From: Sue Howell
Sent: 08 May 2017 15:42
To: Planning.Responses
Cc: David Innes
Subject: RE: Planning Consultation on A/47/17/DOC

Application A/47/17/DOC is seeking discharge of Condition 18. Condition 18 of application A/144/15/PL requires the laying out of details, timetable for provision, future maintenance of public Open Space. Boundaries to be defined, their proposed use, the items of equipment and means of enclosure.

APPLICATION NO: **A/47/17/DOC**

Description of Works: Application for approval of matters reserved by condition imposed under A/144/15/PL relating to condition 18 for details of Public Open Spaces.

Date 29 JULY 2016 Drawing No. DHA/728/008 Rev. -

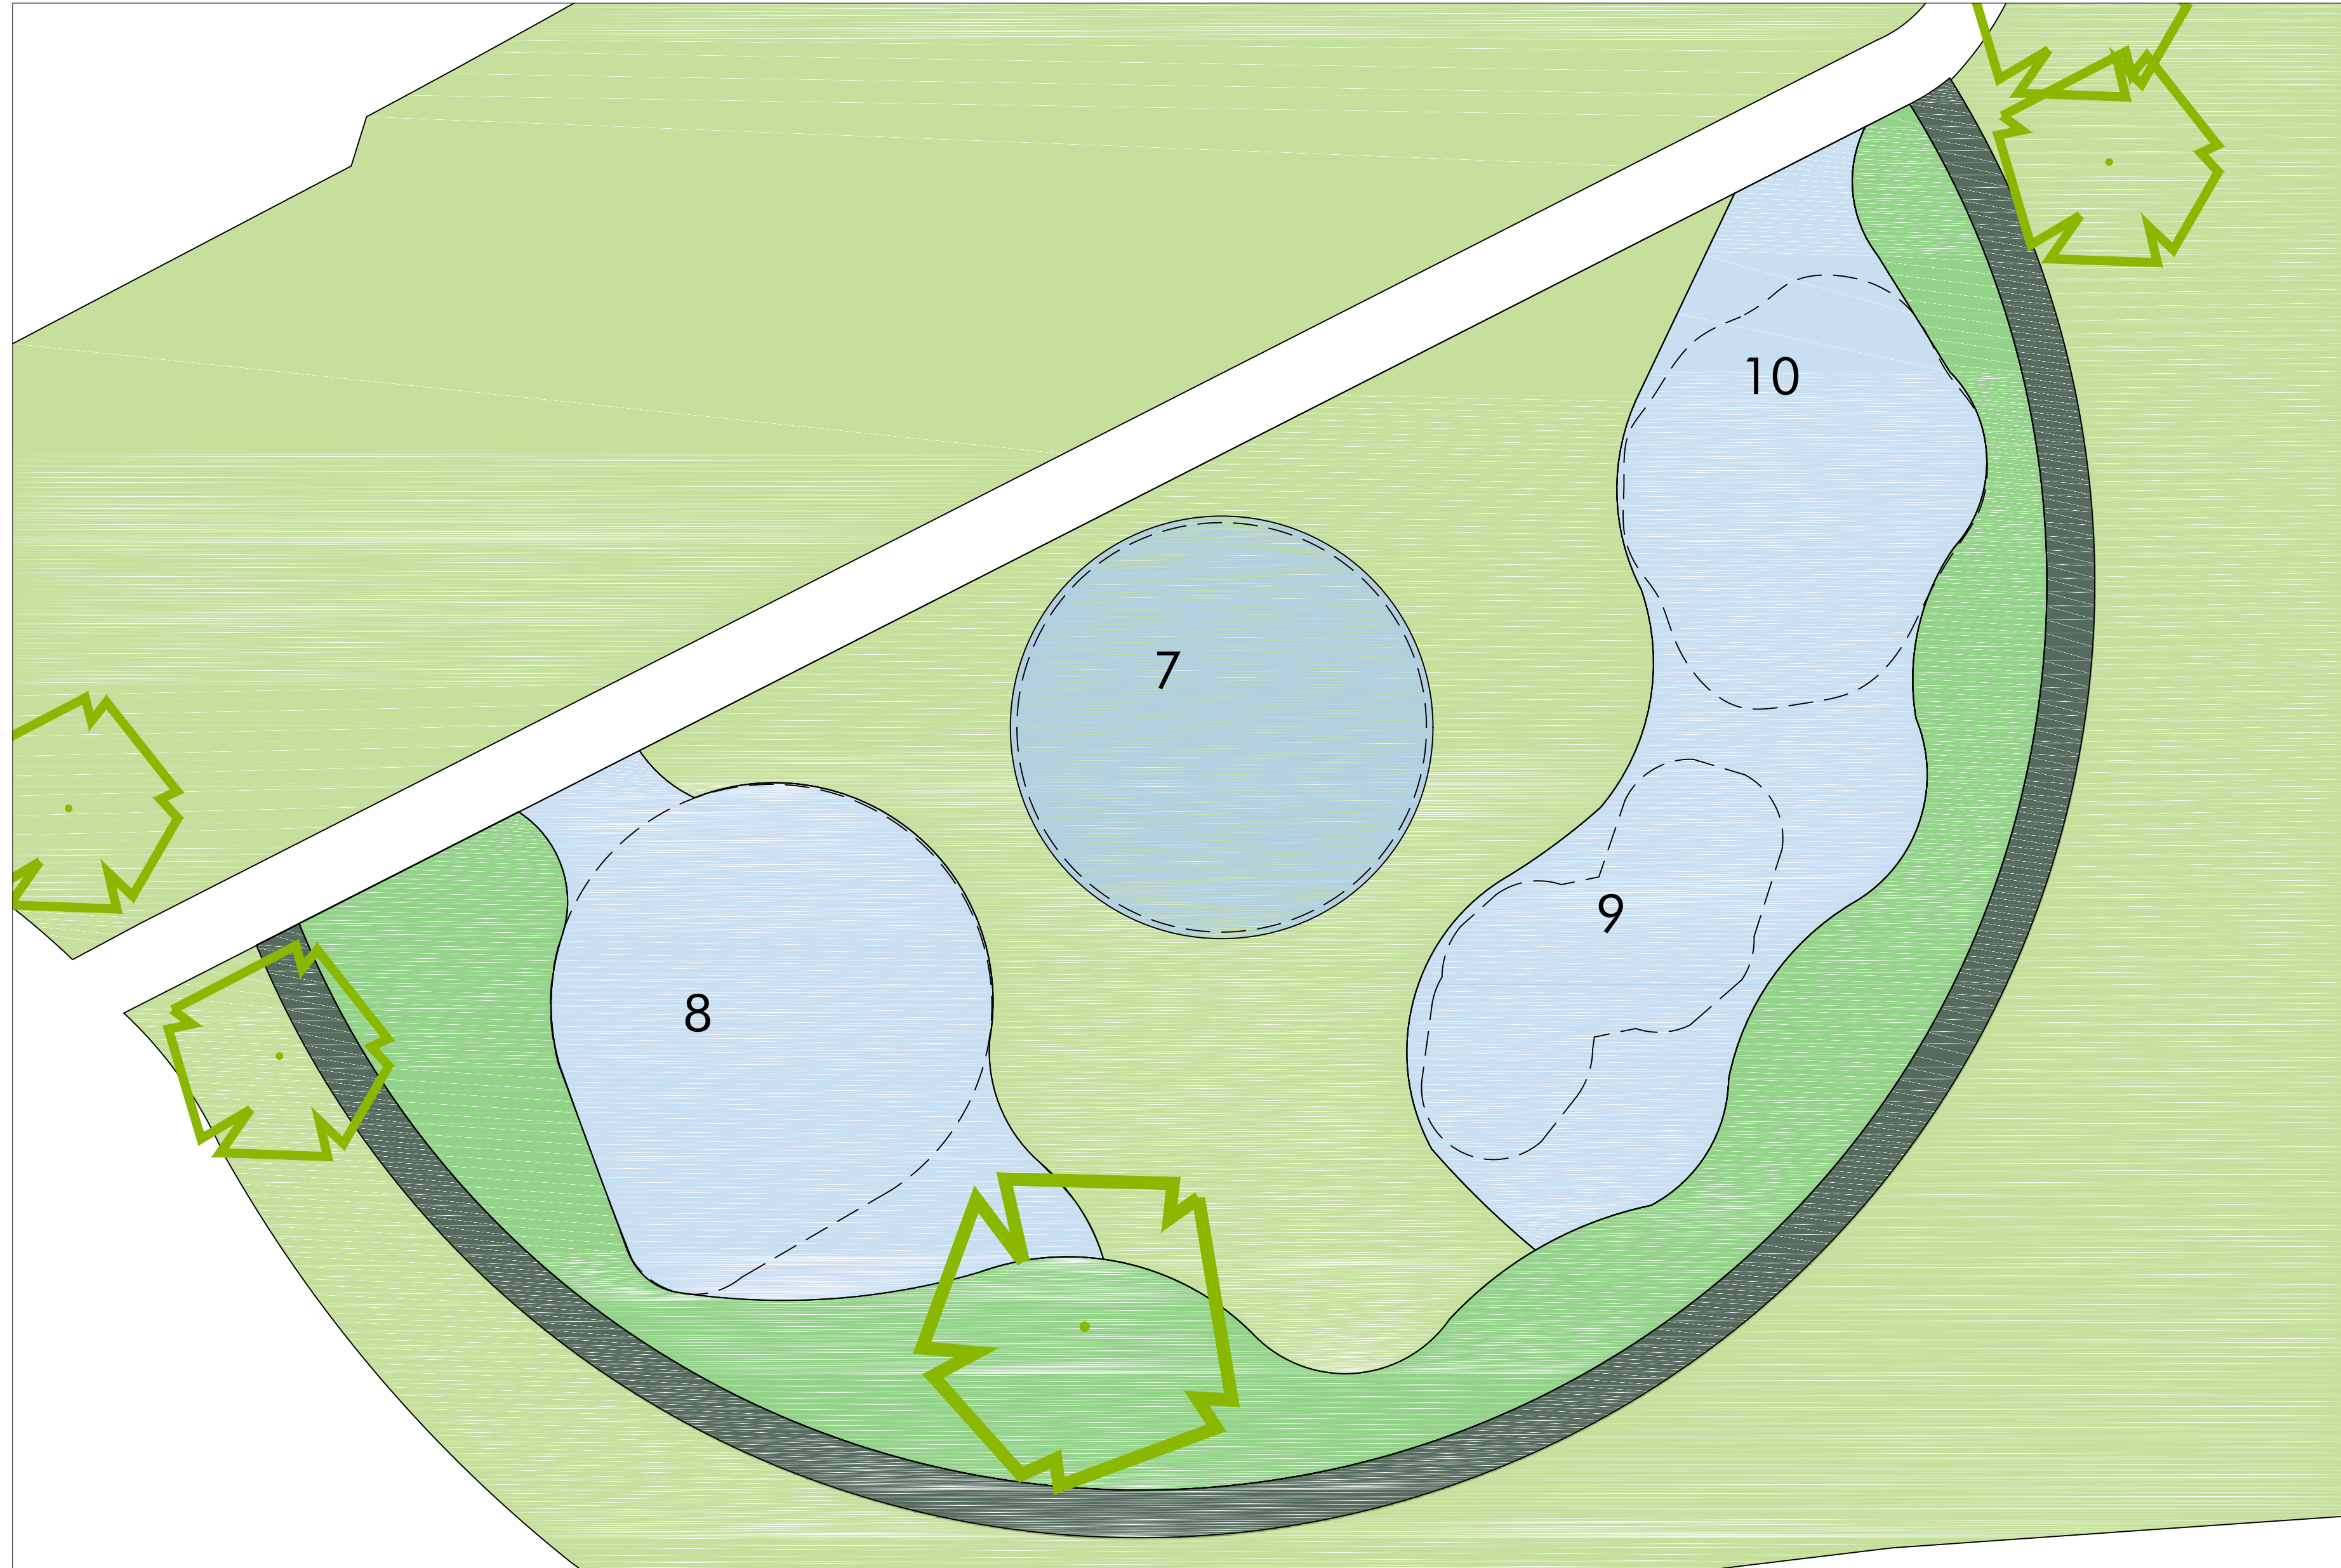
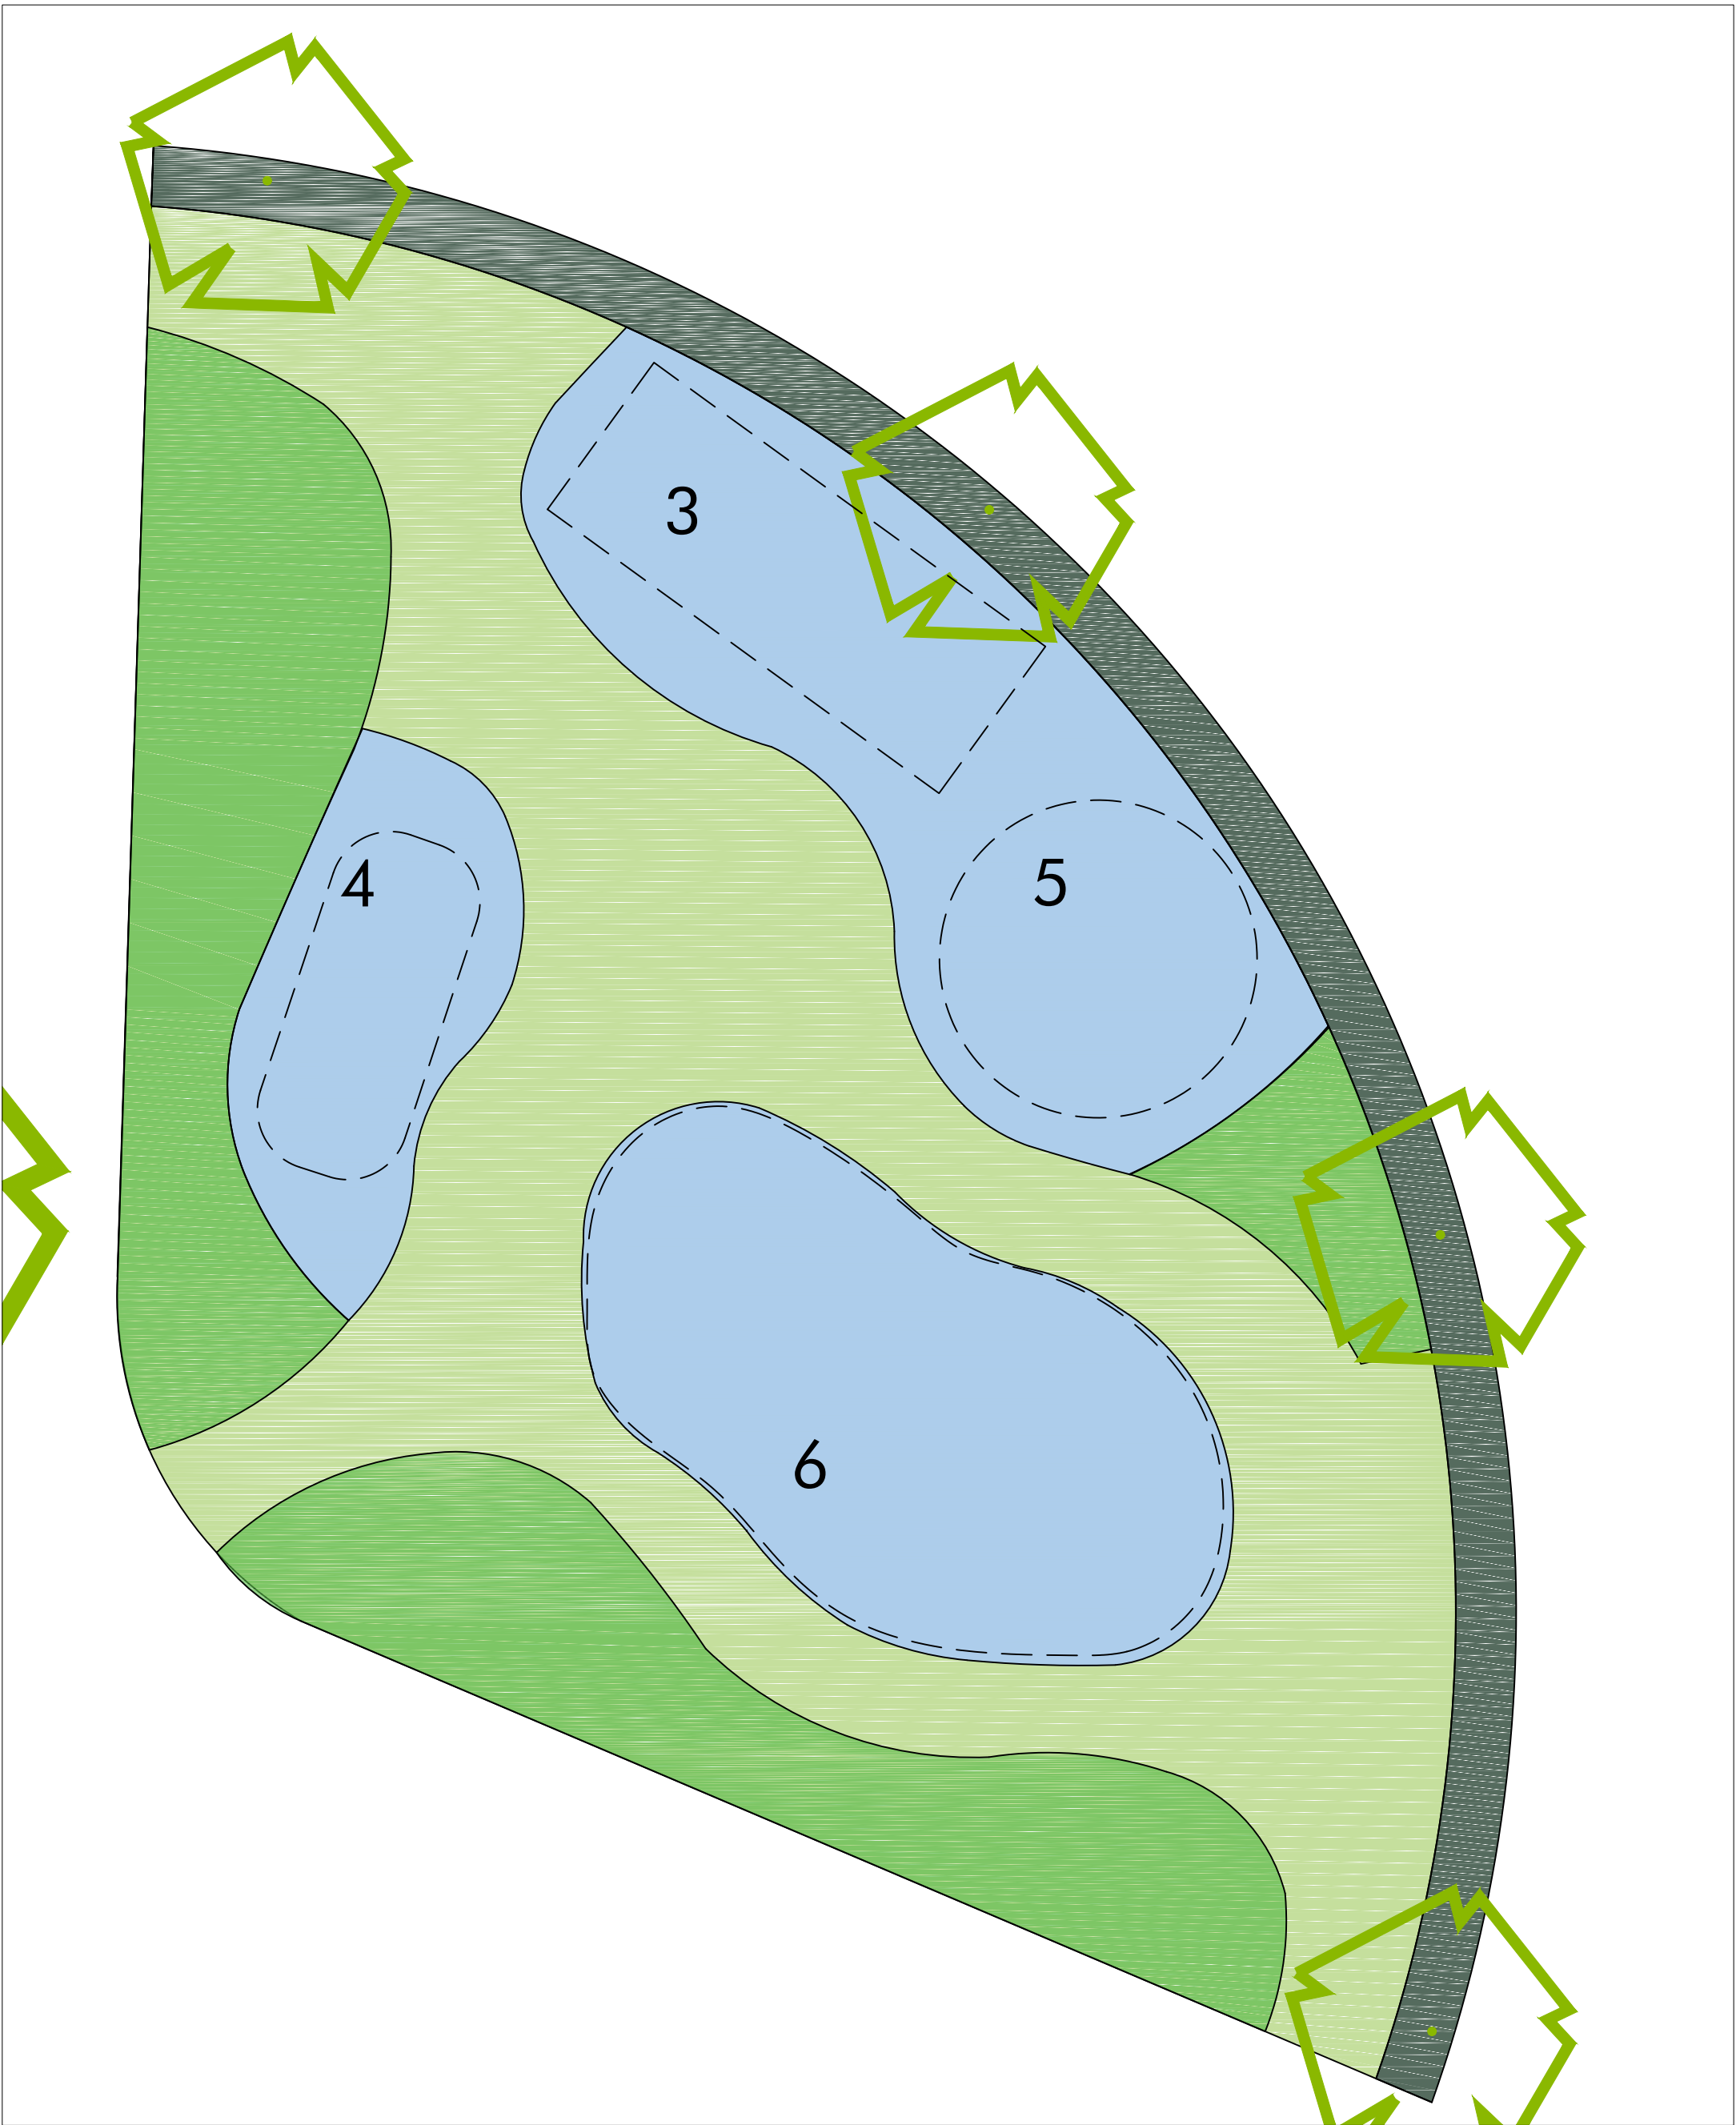
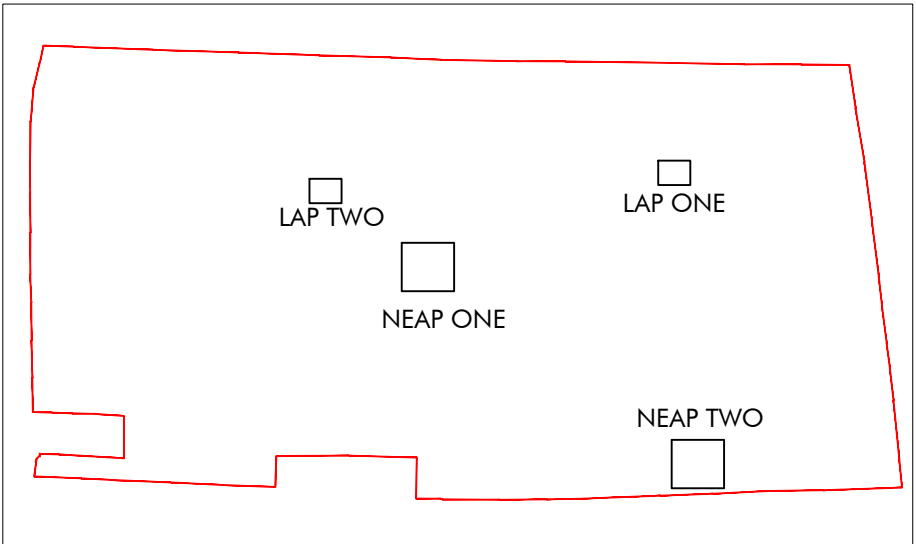
The information submitted within Phase two planting plan, Dwg 15035 P163, DHA/728/008 & DHA/728/011 provides adequate detail of the proposals which we would advise are suitable for location having considered age range provision and experiences being provided. The landscaping scheme proposed is good and will provide enhancement to the built up area, improving the habitat potential and biodiversity within the site. The laps being provided we note are shown as equipped, these can be as effective by just providing small areas of open space specifically designated and primarily laid out for very young children to play close to where they live. The splitting of the NEAP whilst not ideal, does cater for the requirements and would not be detrimental to the effectiveness of this provision. The choice of equipment has been well thought out and the play offer good. Cala Homes have confirmed that the open space and play areas will be retained under Management Company and will not be transferring to the Local Authority. We would note as an advisory that a ROSPA inspection is carried out to the play areas in relation to the waterbodies within the site.
